Your Reference SSD-77260958
Michelle Niles
Department of Planning, Industry and Environment
Via Major Projects Planning Portal

29 September 2025

**Response to Submission to SSDA
20-24 Railway Parade and No.2-4 Burleigh Street, Burwood
Mixed Use Development**

LEVELS 3-18 BALCONY SIZES DUAL KEY

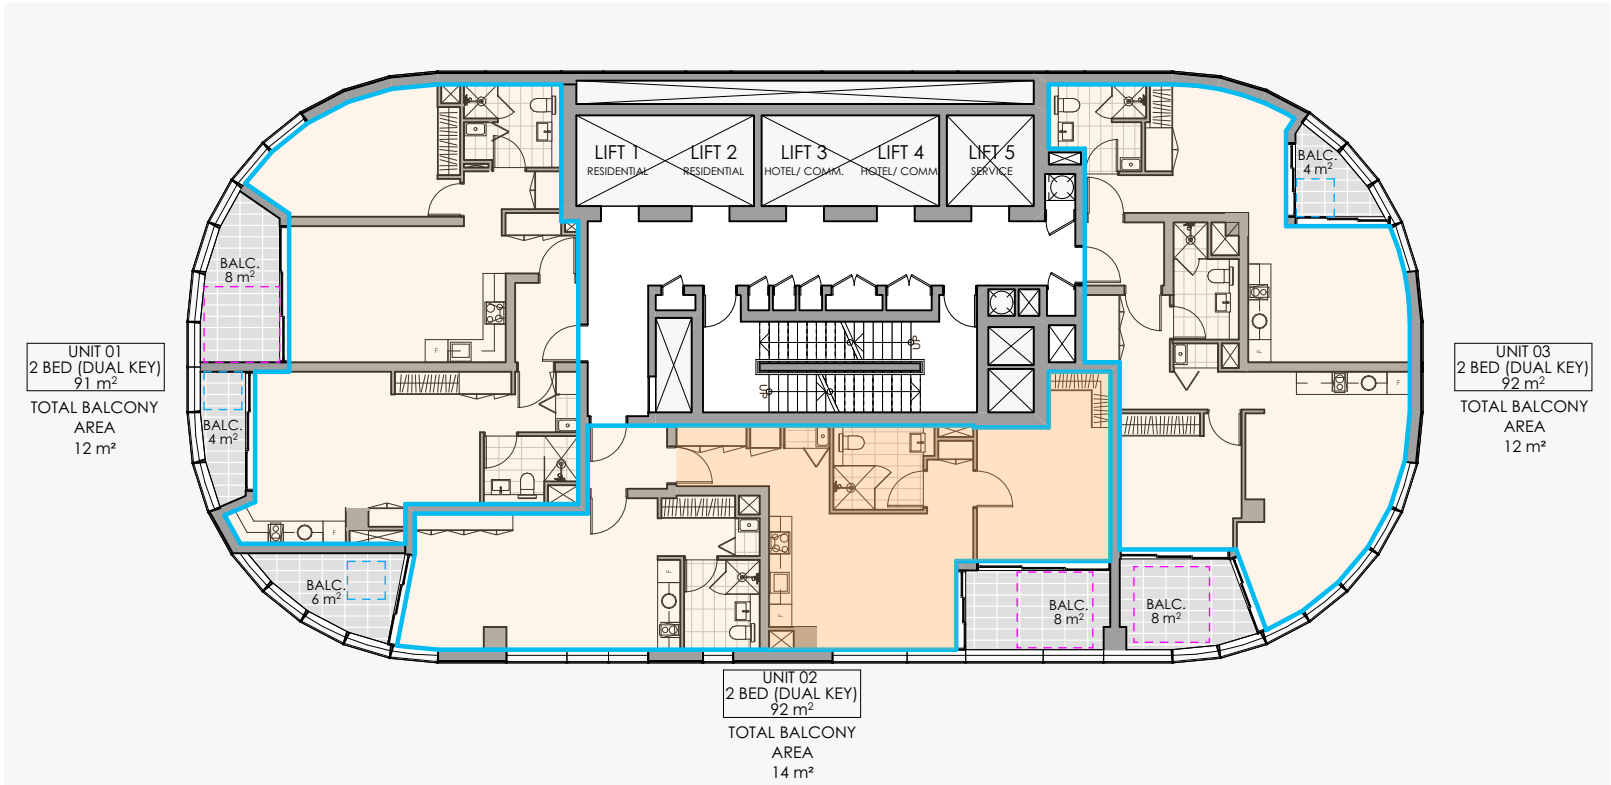
- A preliminary review of the amended plans undertaken by Council has identified that the balcony areas meeting the minimum required depths for Units 01A, 02B, 03A, and 30B do not comply with the minimum balcony area requirements outlined in the ADG.

- In addition, the revised architectural plans have not excluded the portions of the balconies that do not meet the minimum depth requirement, and the total balcony areas indicated on the plans are therefore inaccurate.

- A revised balcony design is required to ensure that sufficient compliant private open space is provided, and that balcony areas with non-compliant depths are minimised or excluded in accordance with the requirements from ADG.

- Additionally, the rounded corners of the tower have significantly reduced the portions of balconies that can achieve compliant depths. The current building form undermines both the amenity and functionality of the apartment balconies.
